From: Carmichael Ian <Ian.Carmichael@thamesvalley.pnn.police.uk>
Sent: 13 March 2020 13:33
To: Matthew Chadwick
Cc: Planning
Subject: Planning Ref: 19/02796/F (AMENDMENTS). Recreation Ground, MUGA and Pavilion. OS Parcels 3309 and 4319 Adjoining and North of Milton Rd Adderbury.

Planning Ref: 19/02796/F (AMENDMENTS). Recreation Ground, MUGA and Pavilion. OS Parcels 3309 and 4319 Adjoining and North of Milton Rd Adderbury.

Planning Ref: 19/02796/F. Recreation Ground, MUGA and Pavilion. OS Parcels 3309 and 4319 Adjoining and North of Milton Rd Adderbury.

Fig 46: Ground Floor Plan as proposed showing general arrangement of accommodation

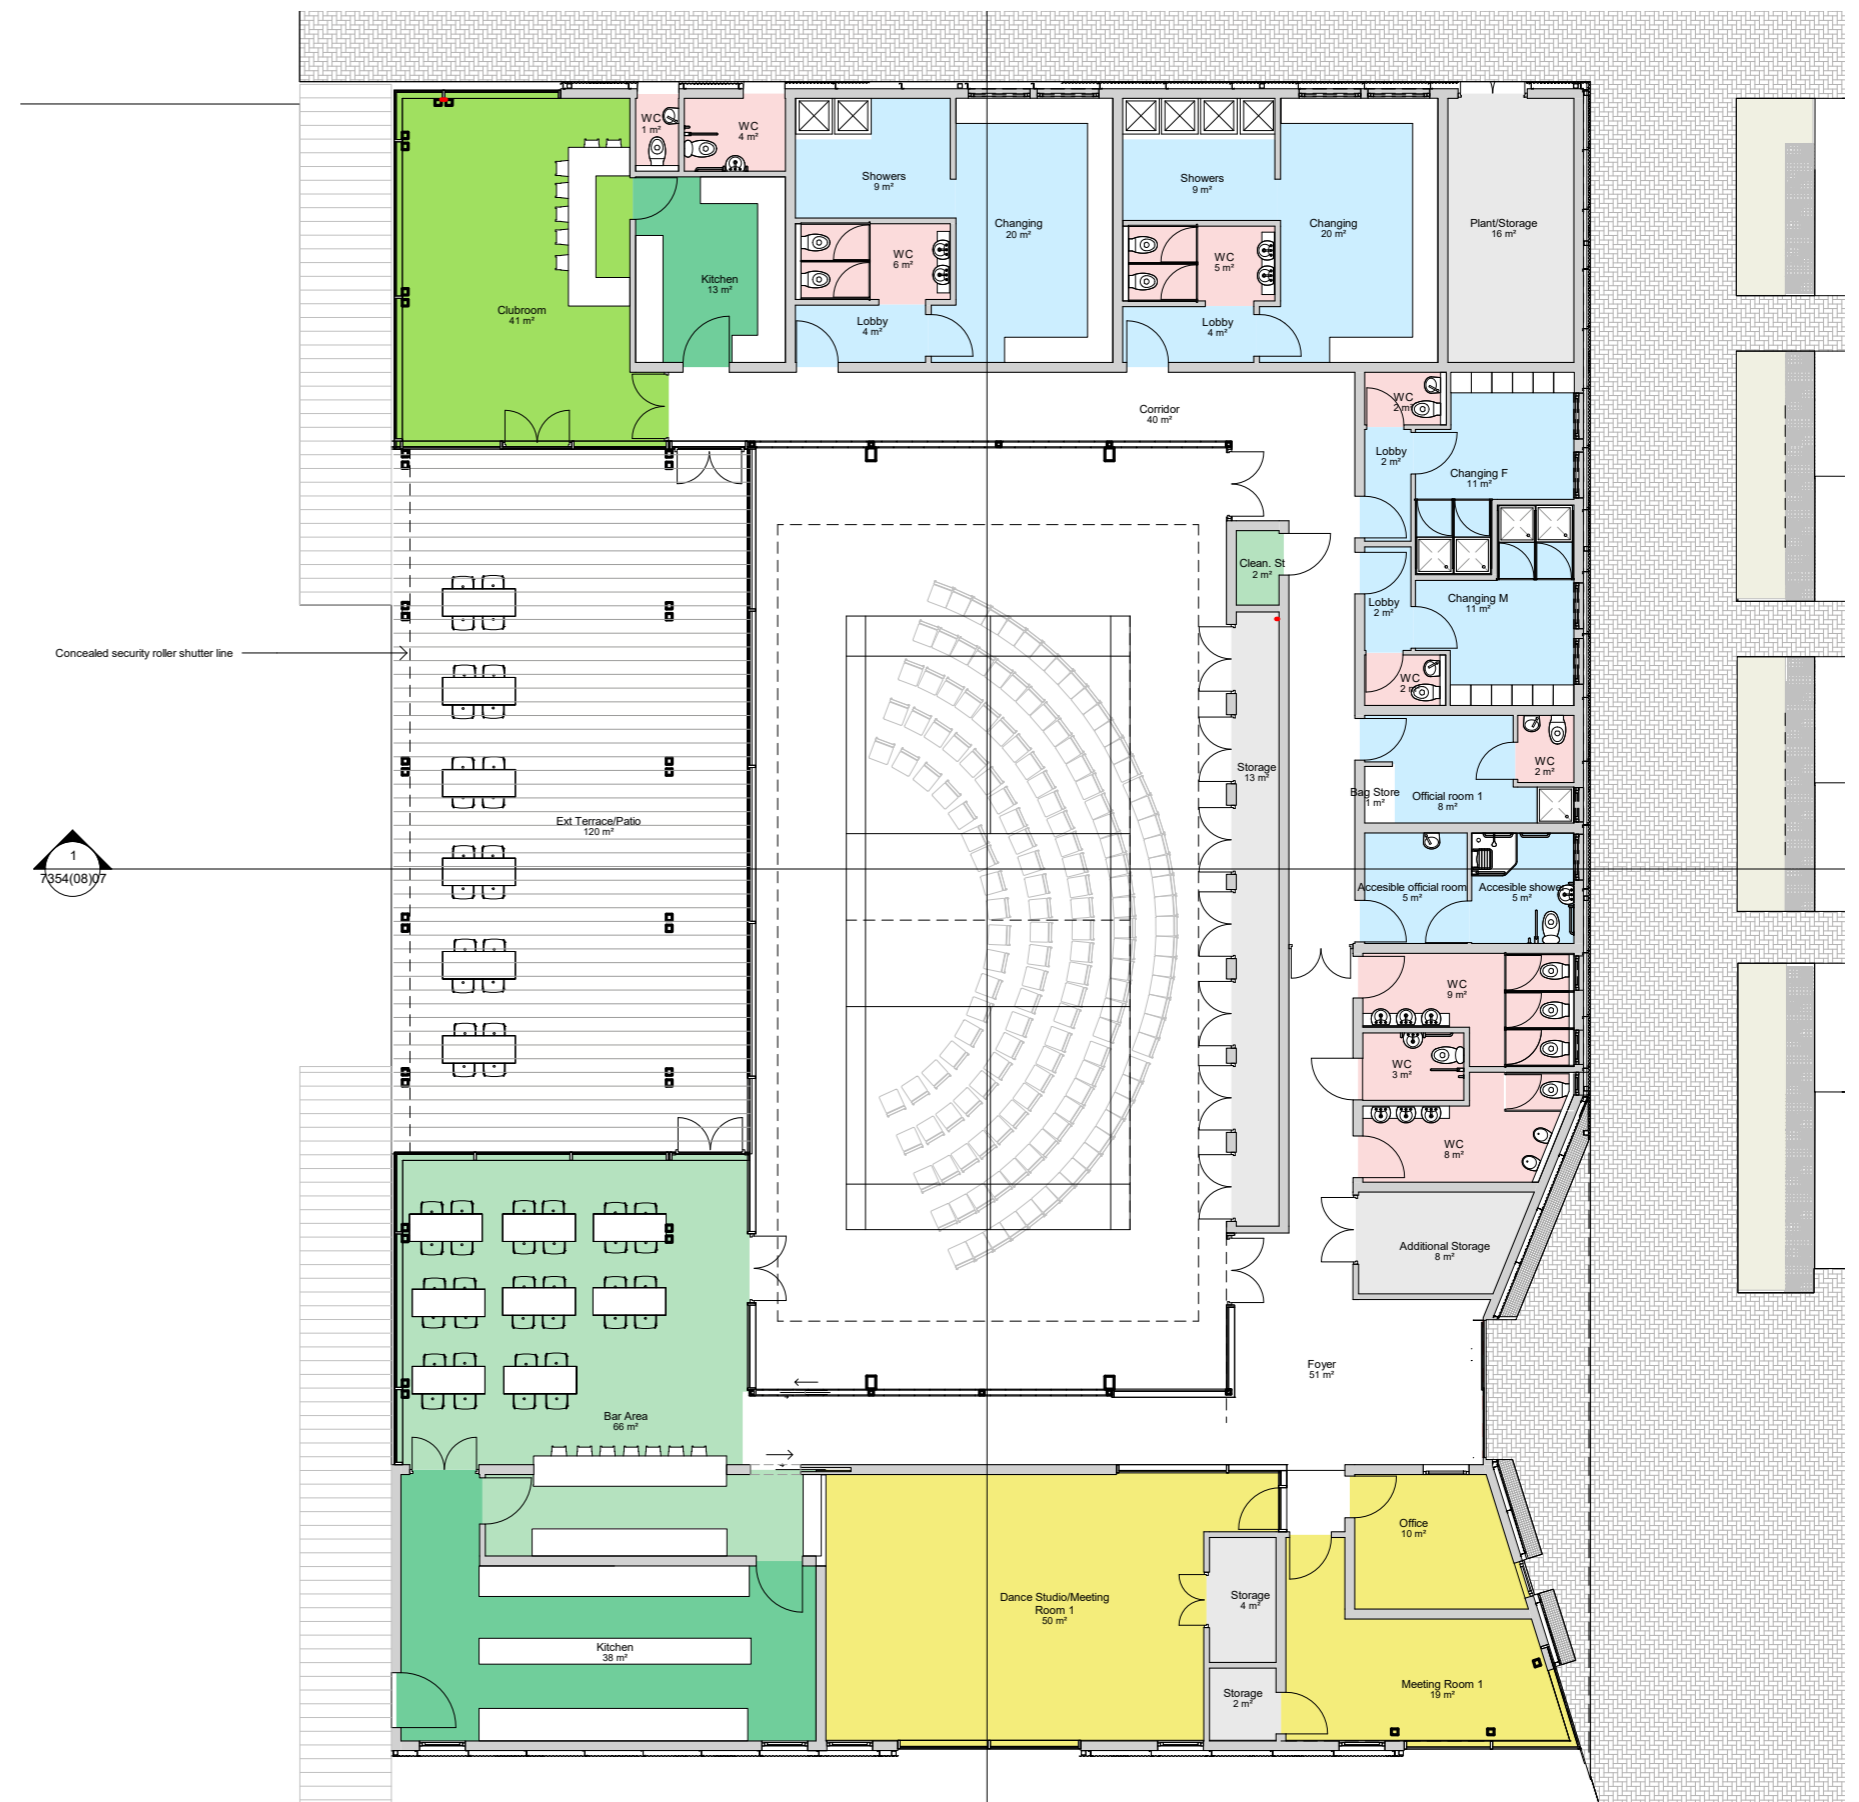
- The recessed entrance to the pavilion and the covered external terrace concern me as such areas are often used as impromptu youth shelters and can attract ASB as well as conceal other criminal activity. I recommend these covered areas are designed out. In addition, I suggest that a secondary set of doors is provided internally at the main entrance so that access can be controlled by users of the facility that may be more vulnerable, or are made so by the remote location of the premises or the time of day.
